29 January 2021

Department of Planning, Industry & Environment
4 Parramatta Square
12 Darcy Street
PARRAMATTA NSW 2150

Hills of Gold Wind Farm (SSD-9679) - Environmental Impact Statement

Project Layout

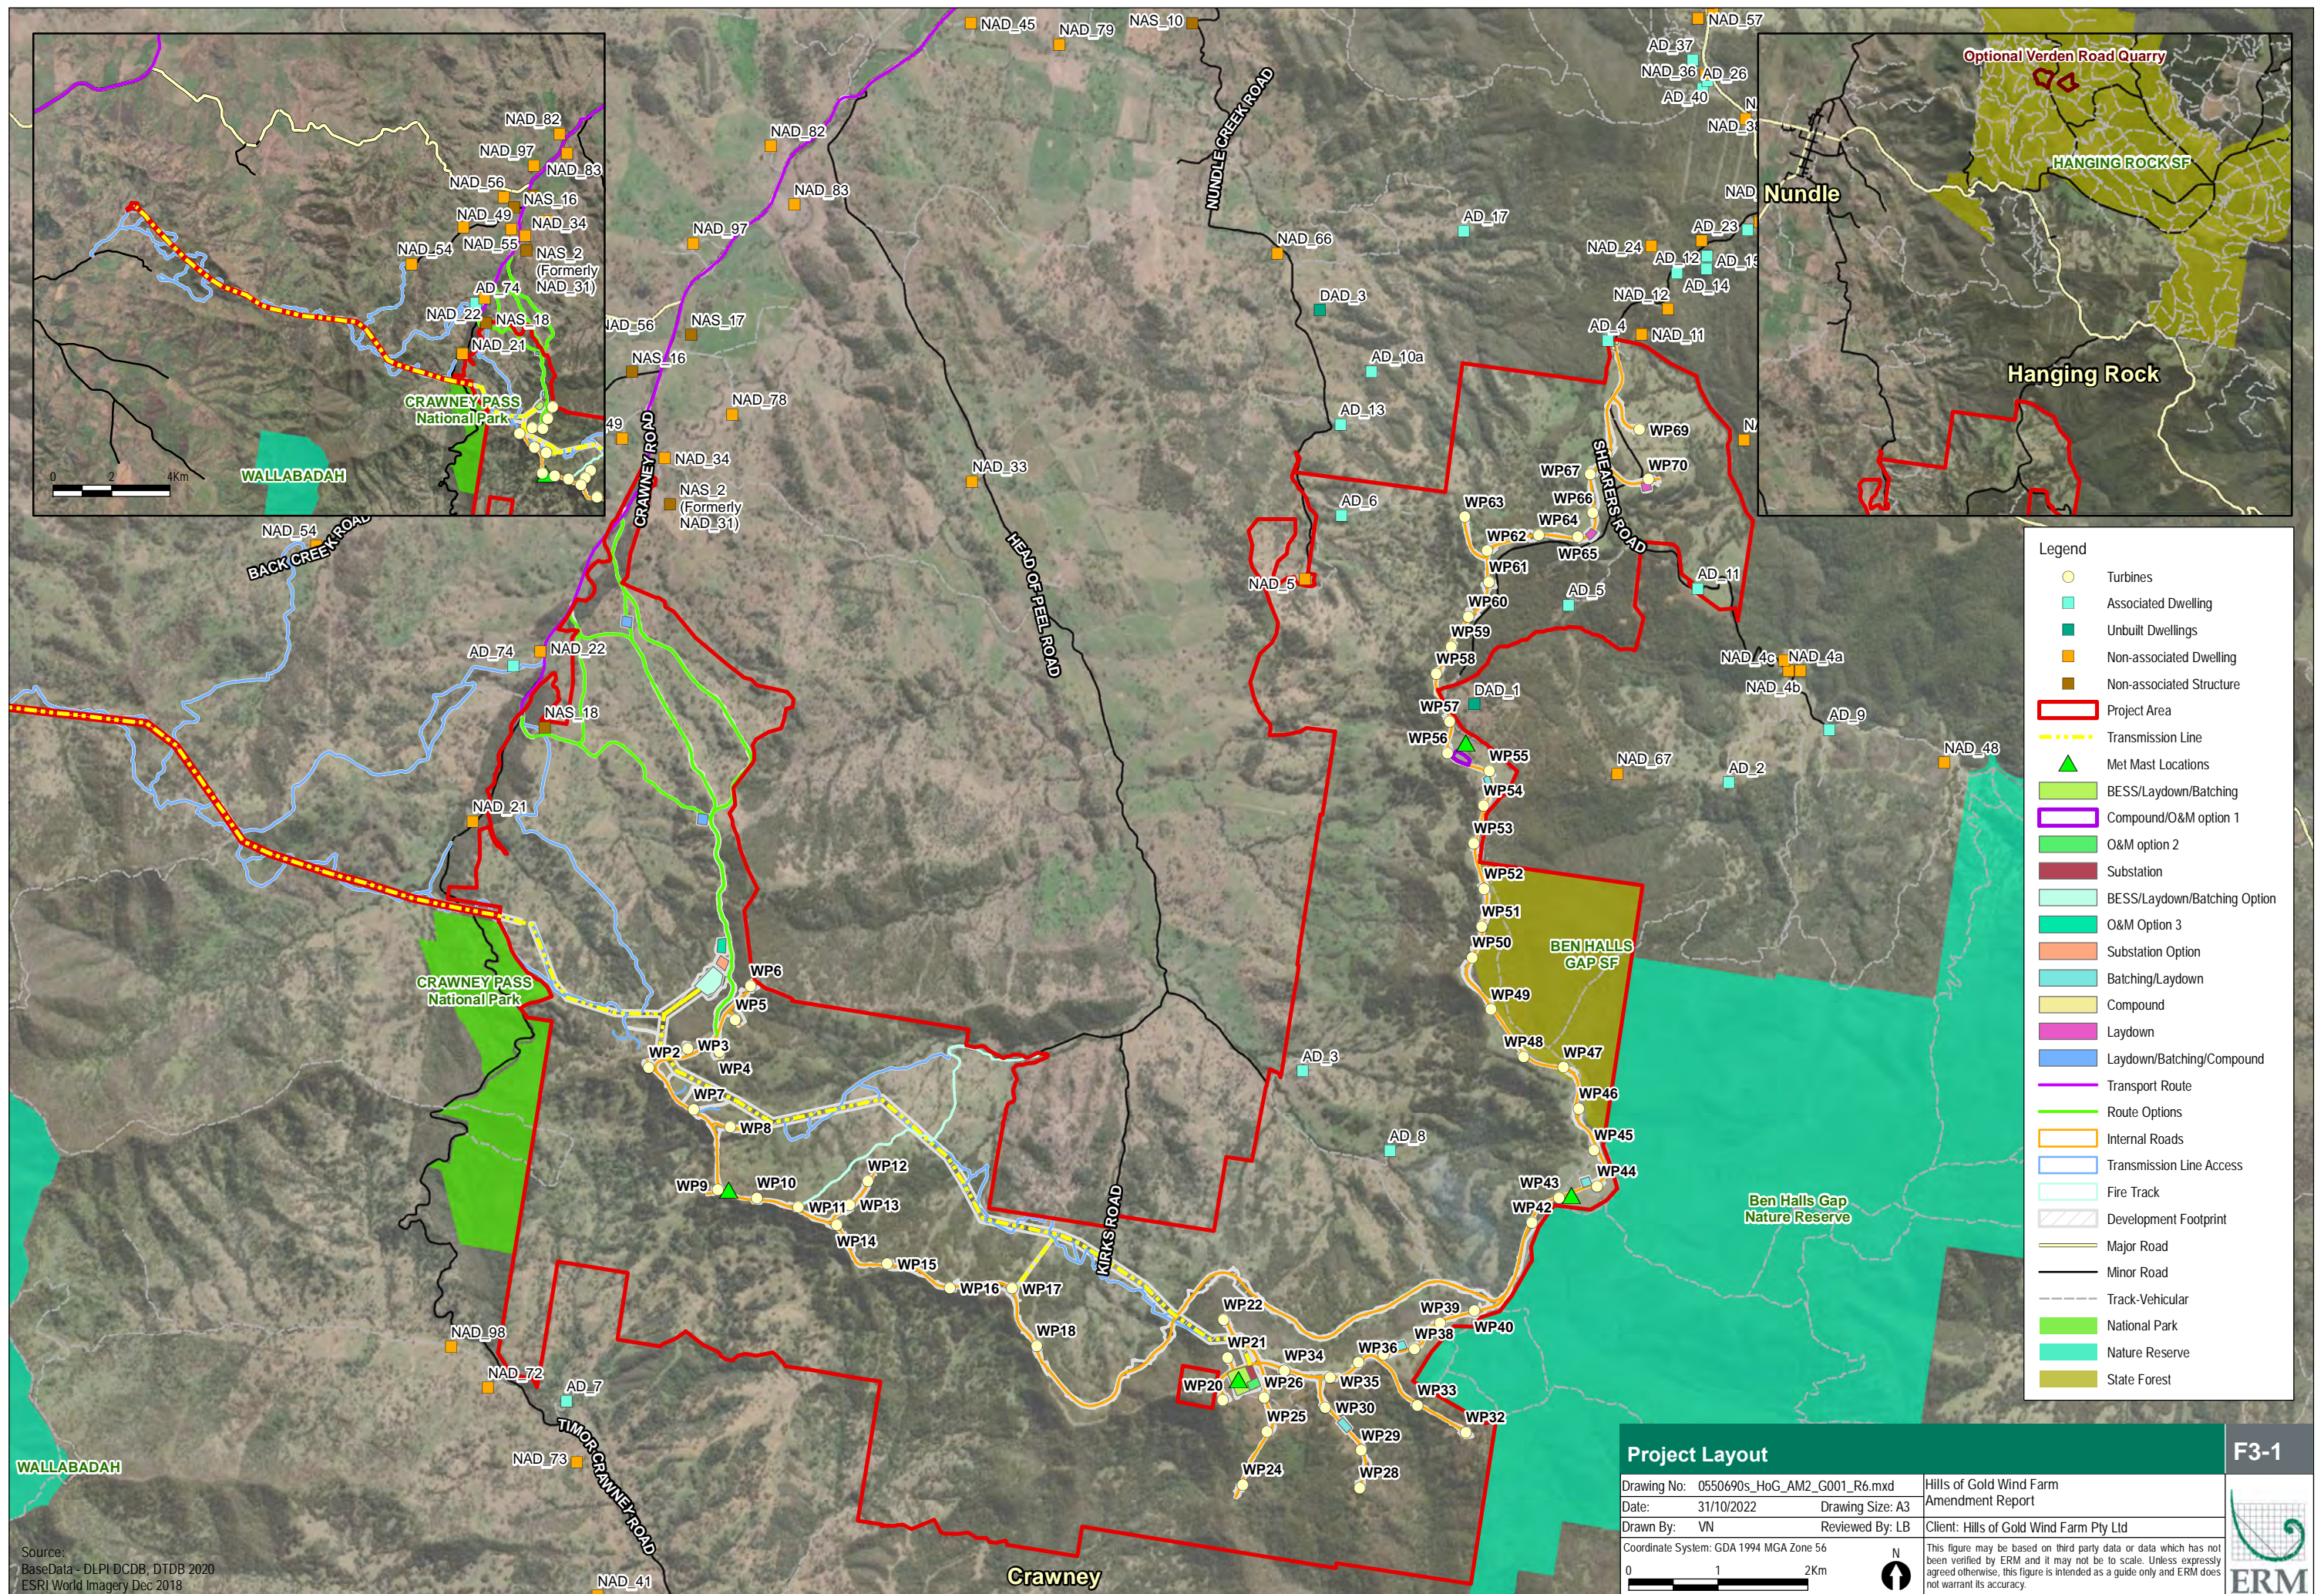
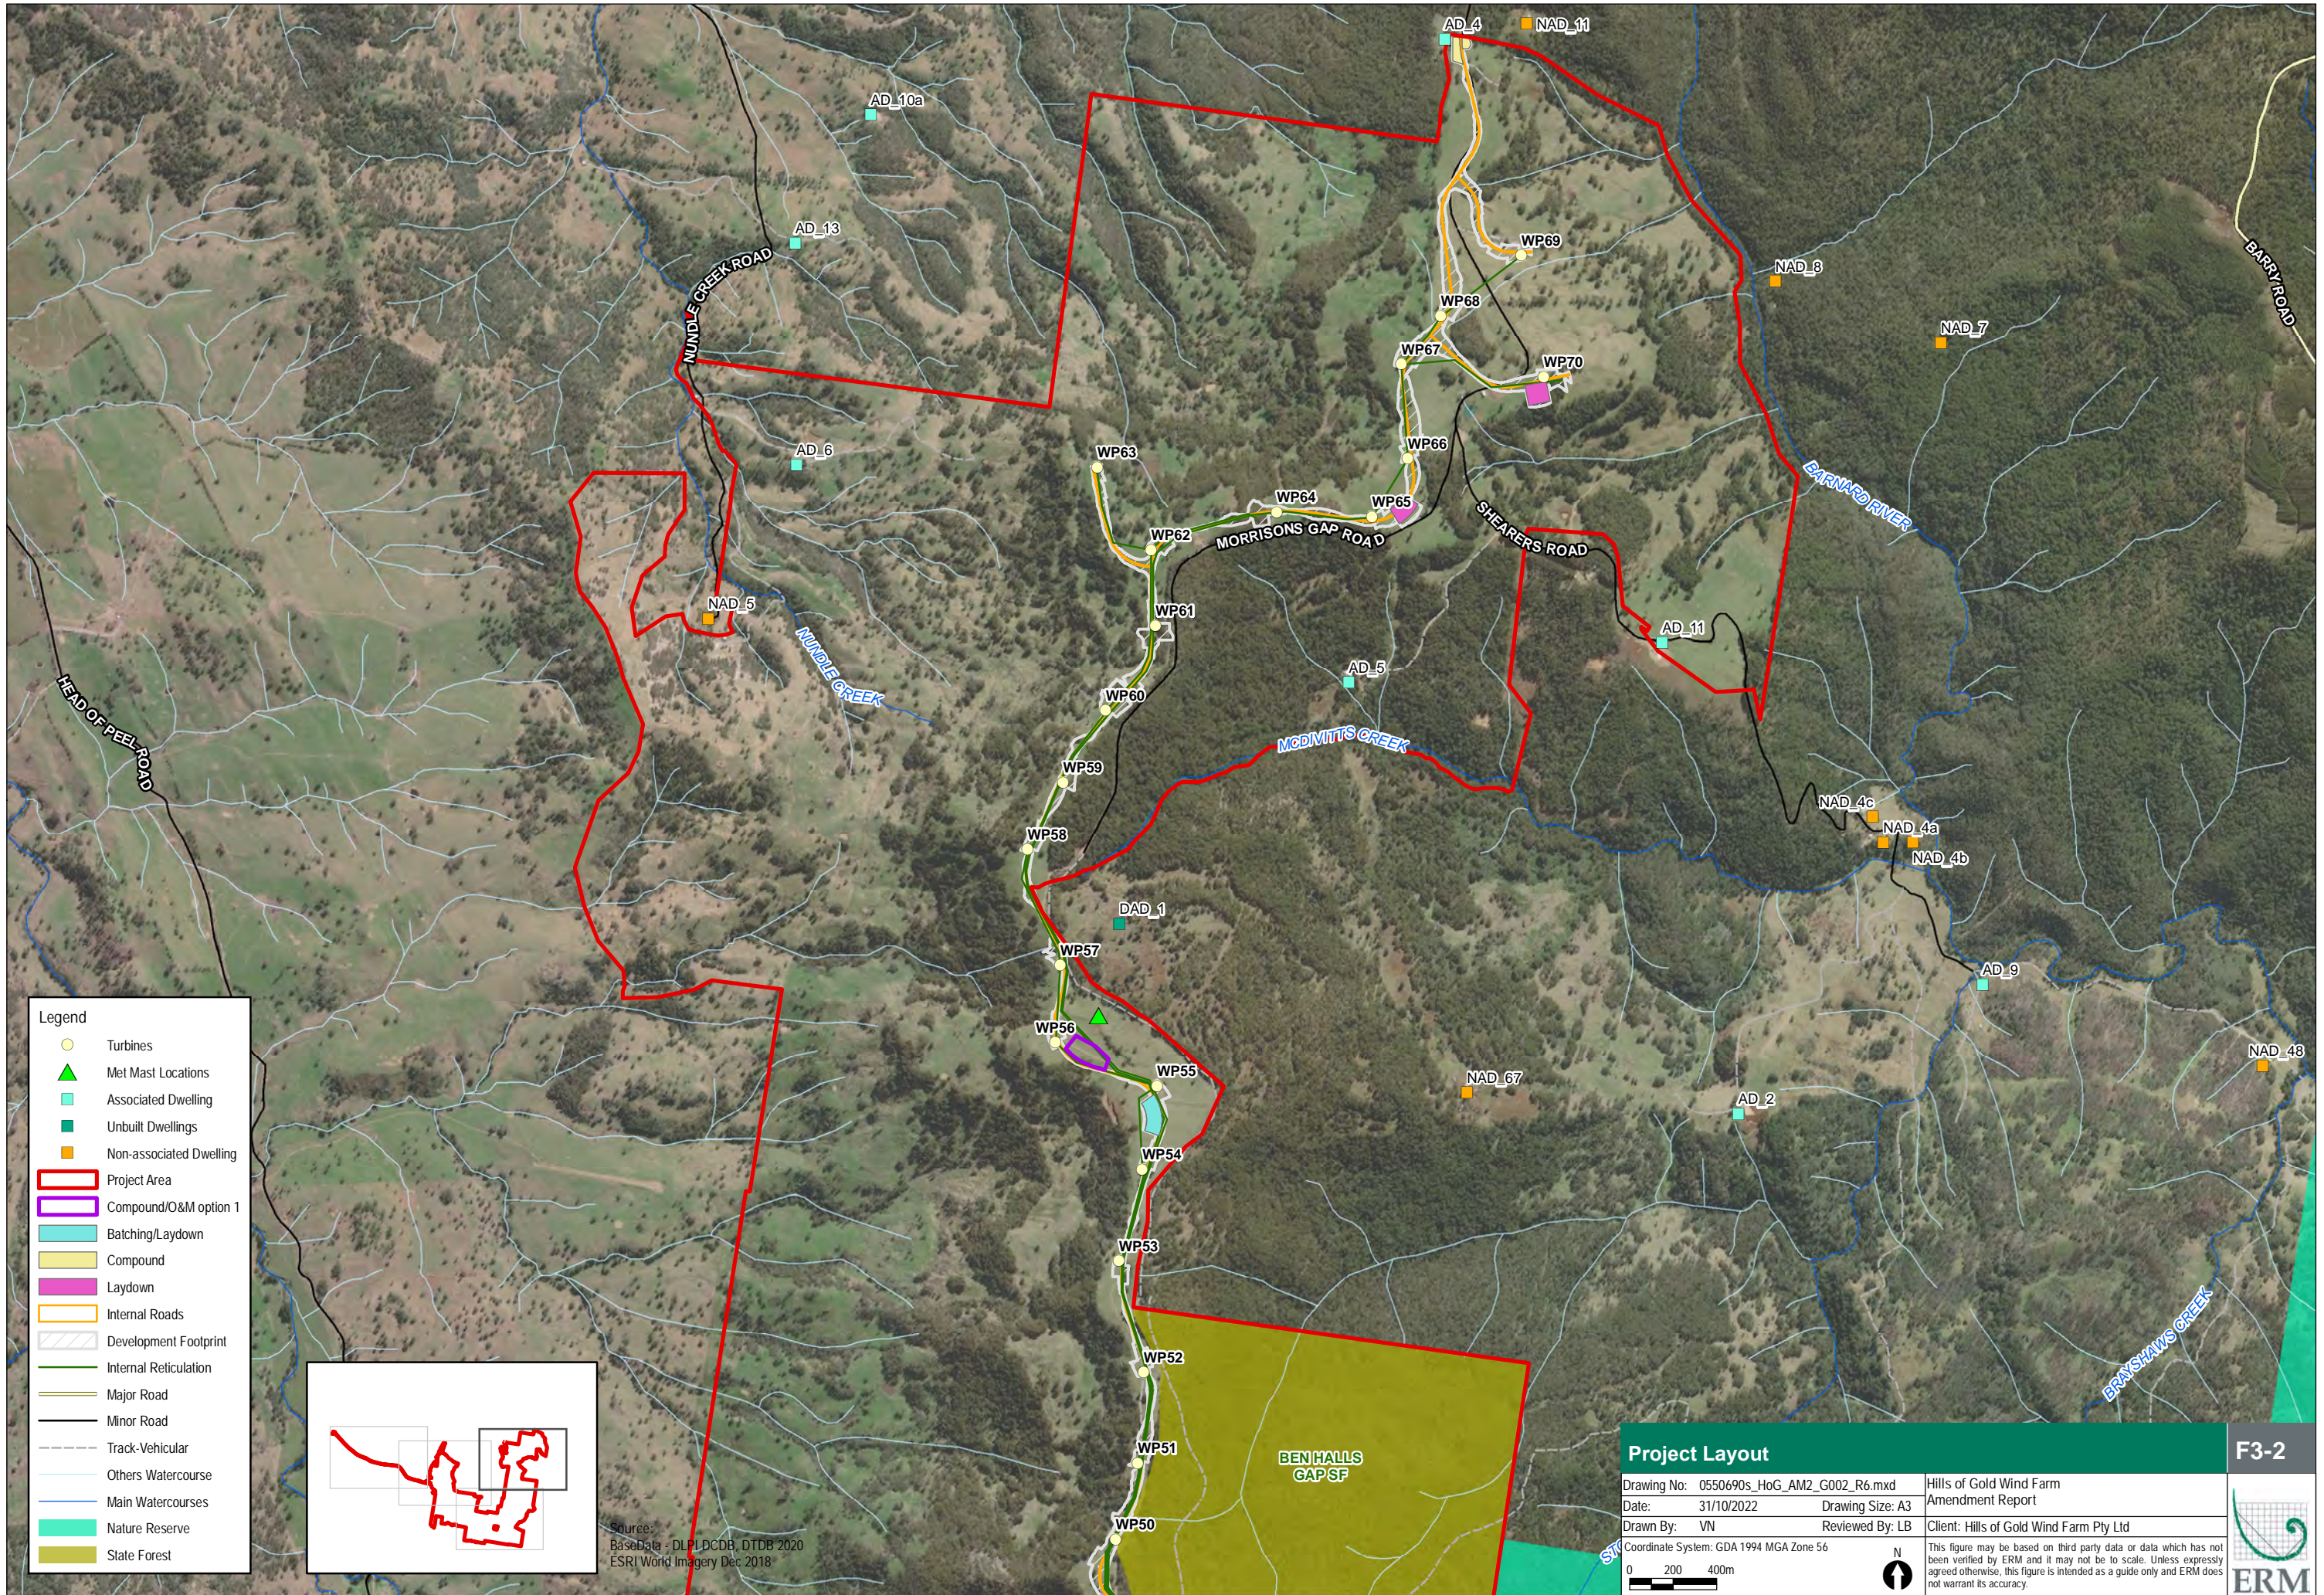
A review of the visual impact assessment raises some concerns in relation to the visual impacts of the wind farm on properties within the Upper Hunter Shire LGA. The proposed wind turbines are densely spaced along the ridgeline forming the LGA boundary and will be highly visible from a number of properties. Consideration should be given to reducing the number of turbines and/or increasing the spacing of the turbines in areas where they are highly concentrated (eg. WP20 – WP39) to mitigate the potential visual impact.
